At s.5ii of 7.62 <https://infrastructure.planninginspectorate.gov.uk/wp-content/uploads/projects/TR010065/TR010065-001004-National%20Highways%20-%207.62%20Comments%20on%20submissions%20received%20at%20the%20previous%20deadline.pdf>. It is stated that 'The Applicant confirms enhancement of the existing drainage system on land East of the A617 is not considered necessary. Maintenance of the existing assets is all that is required for FCA functionality. FCA operation is partly achieved by the preexisting flood flow mechanism across the land east of the A617, not just the ditch itself. This is evidenced in Section 3.3 of Appendix 13.2 (Flood Risk Assessment) of the Environmental Statement Appendices [APP-177]';

We disagree, we consider the culvert near the Haha does need enhancing. We have reviewed the evidence below:-

DRAWING TITLE
 DRAINAGE ENGINEERING PLAN
 REGULATION 5(2)(o), 5(2)(P) and 6(2)
 SHEET 1 OF 7

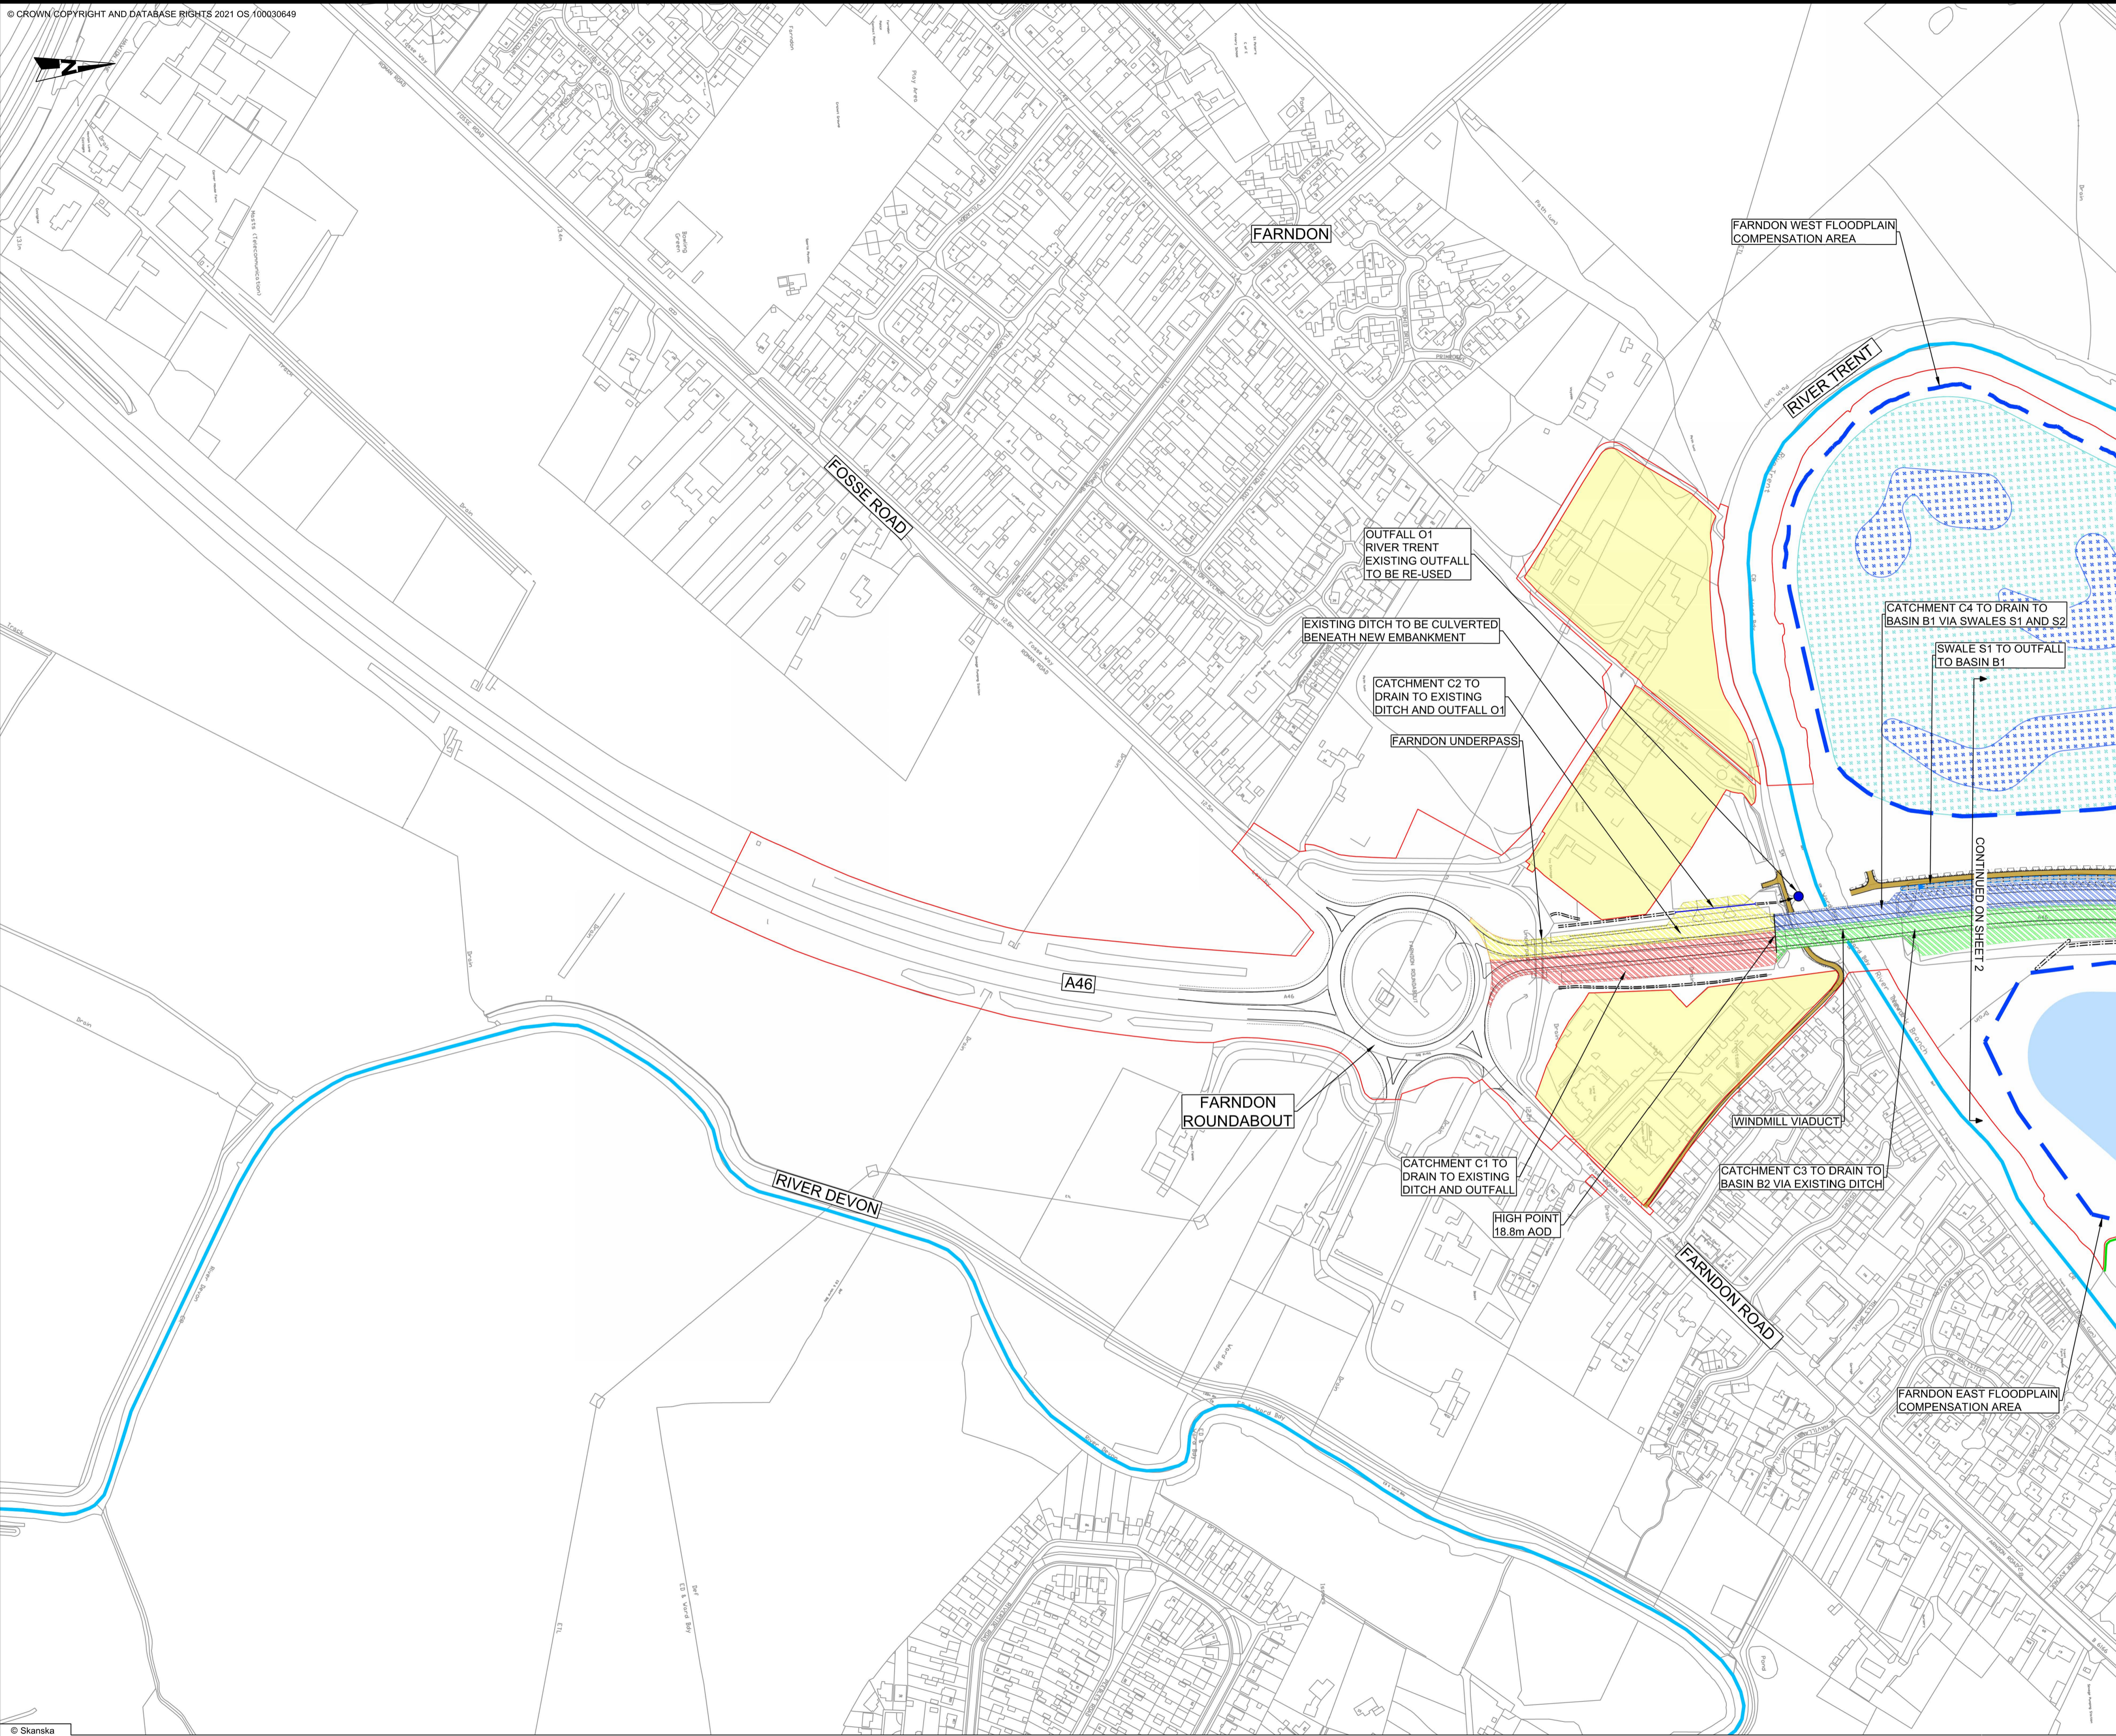
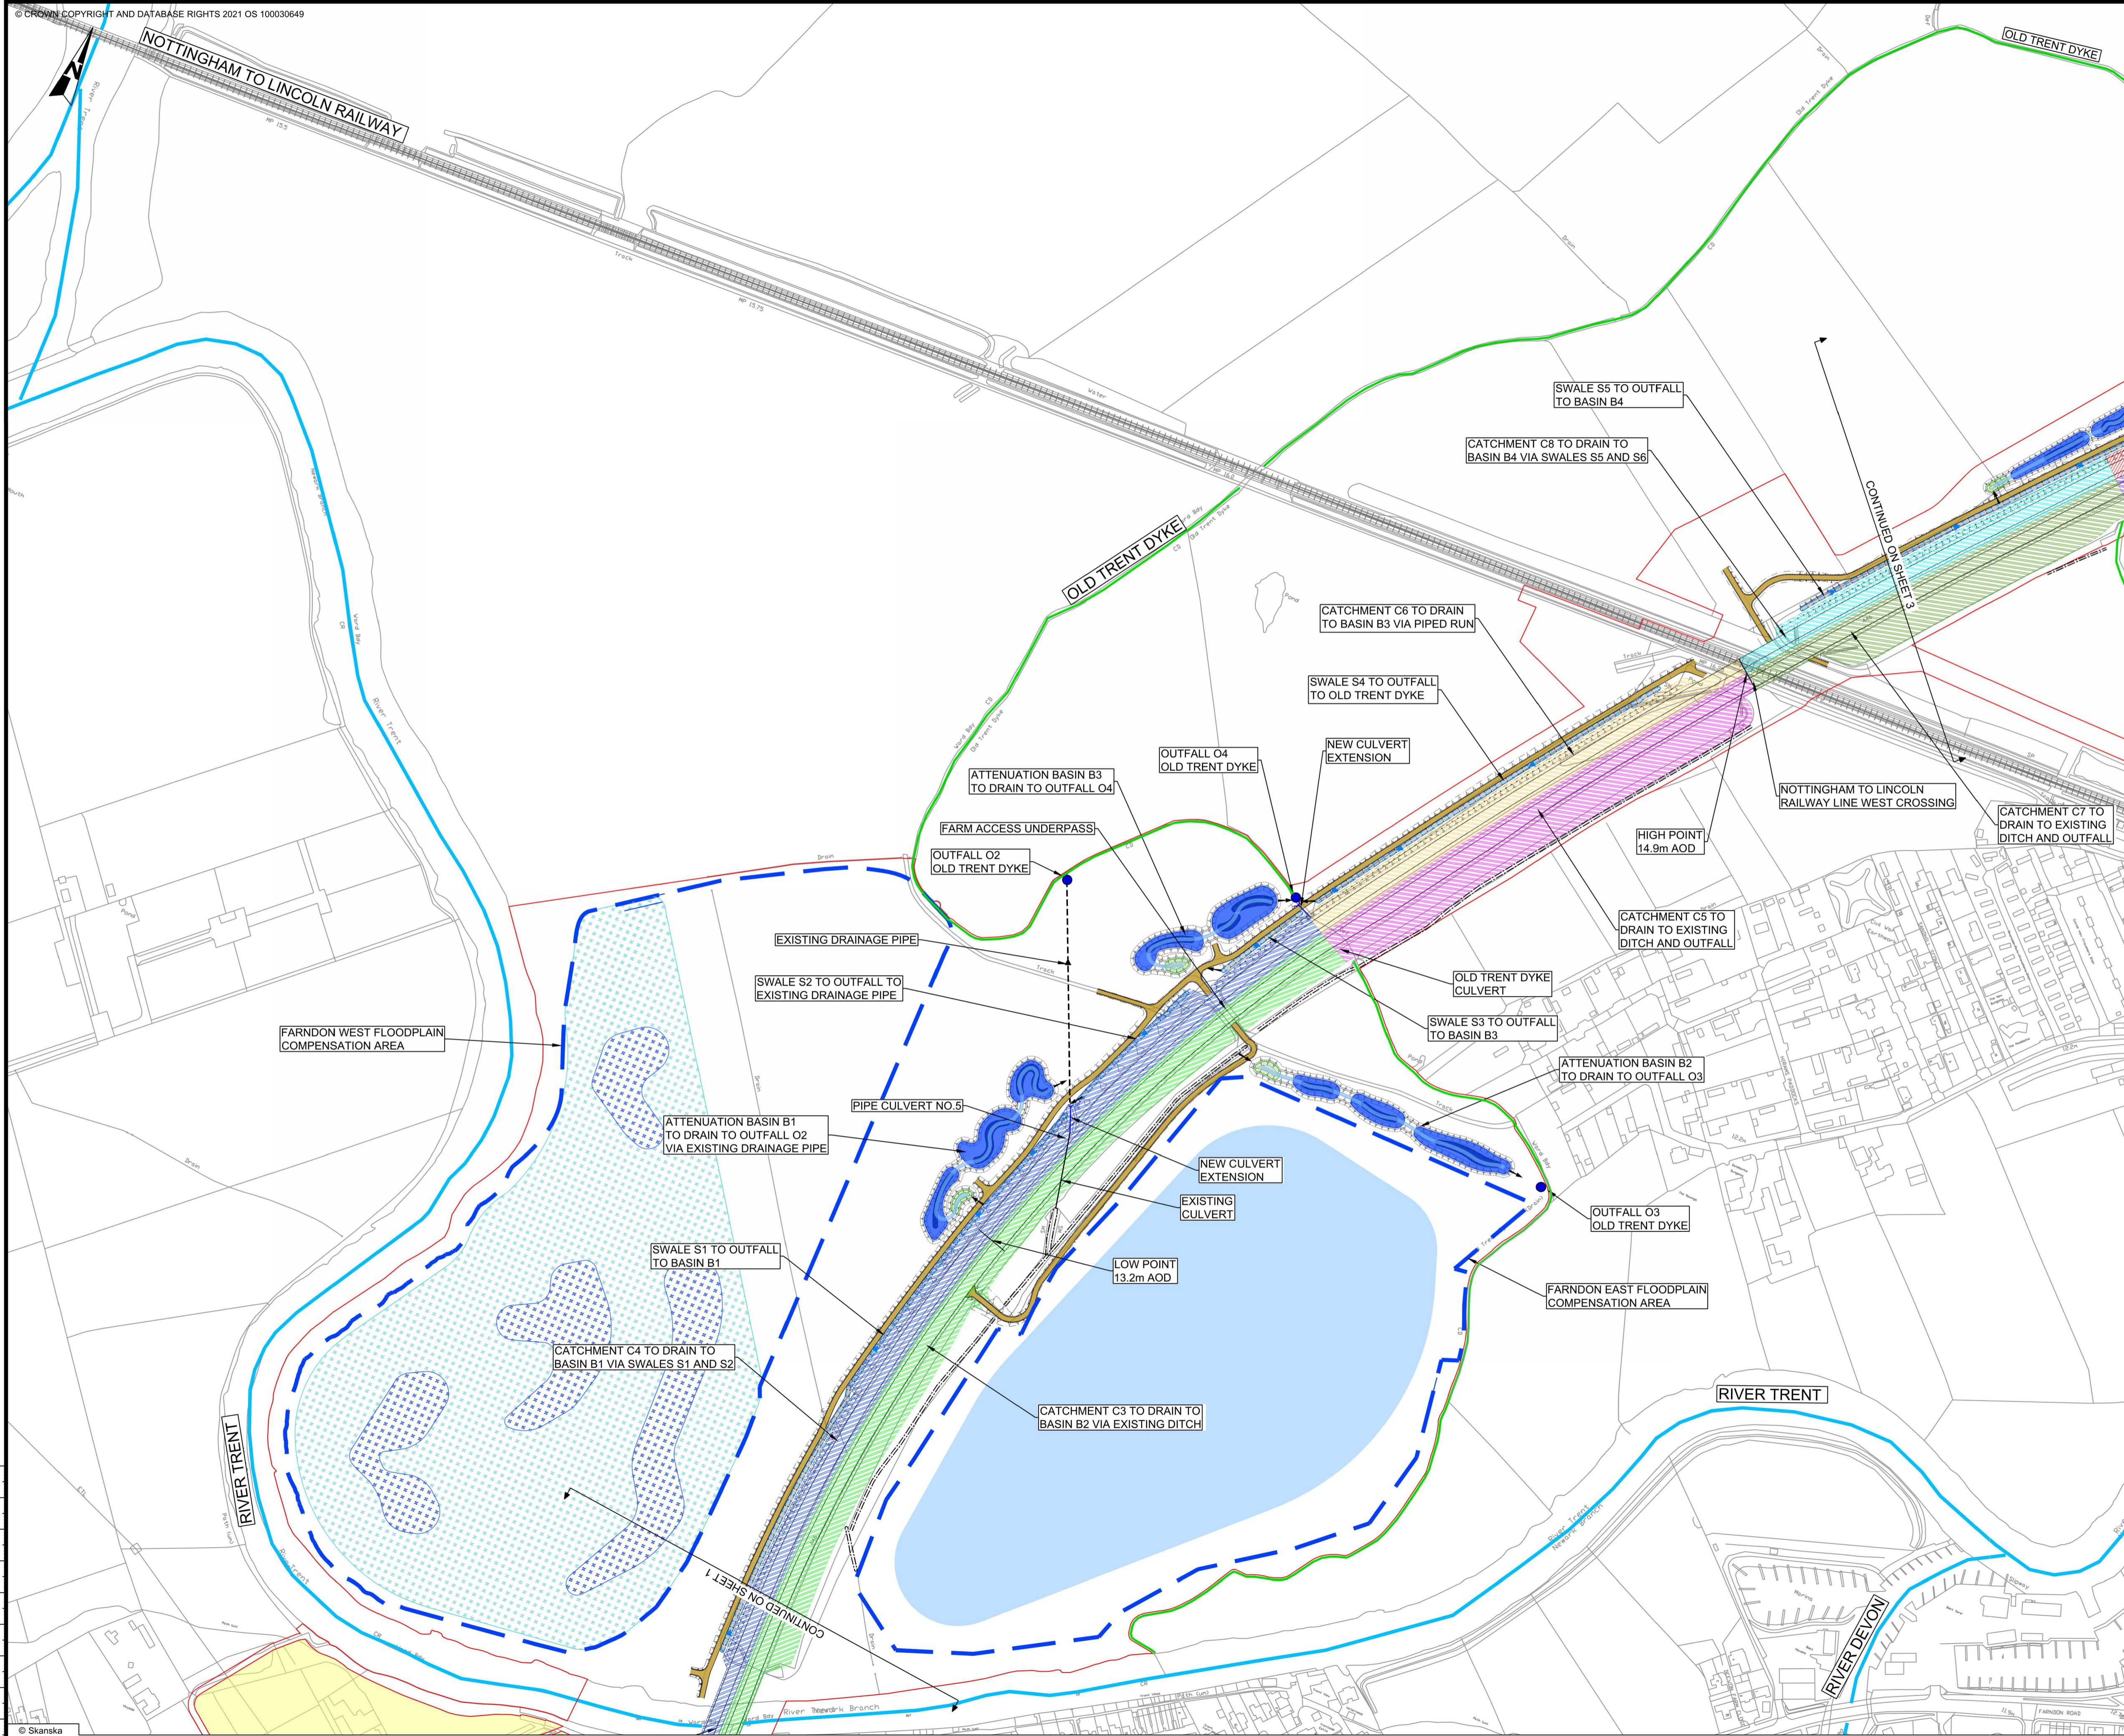
The greatest restriction to flow on that ditch is the small culvert at the Haha crossing.

If an additional several thousand cuM volume of water is to be transported to and from the FCA via that route, at least some of that excess will need to pass through the ditch and culvert as water levels will, at lower flood stages, be below the existing field ground level and unable to use the fields as a flow path.

Having owned the land for over 20 years my client has seen that the Haha culvert blocks frequently due to detritus from Trent floods flowing back up the ditch and needs manually cleaning to facilitate discharge trapped water after almost every flood, which my client has previously undertaken.

My client wants to know how the Applicant proposes to manage this given it recognises the ditch to be a critical part of FCA function but does not propose to alter the culvert design ? If the Applicant sees the ditch as a requirement for FCA function and the ditch needs cleaning for FCA to work, so does the culvert need upgrading to facilitate discharge.
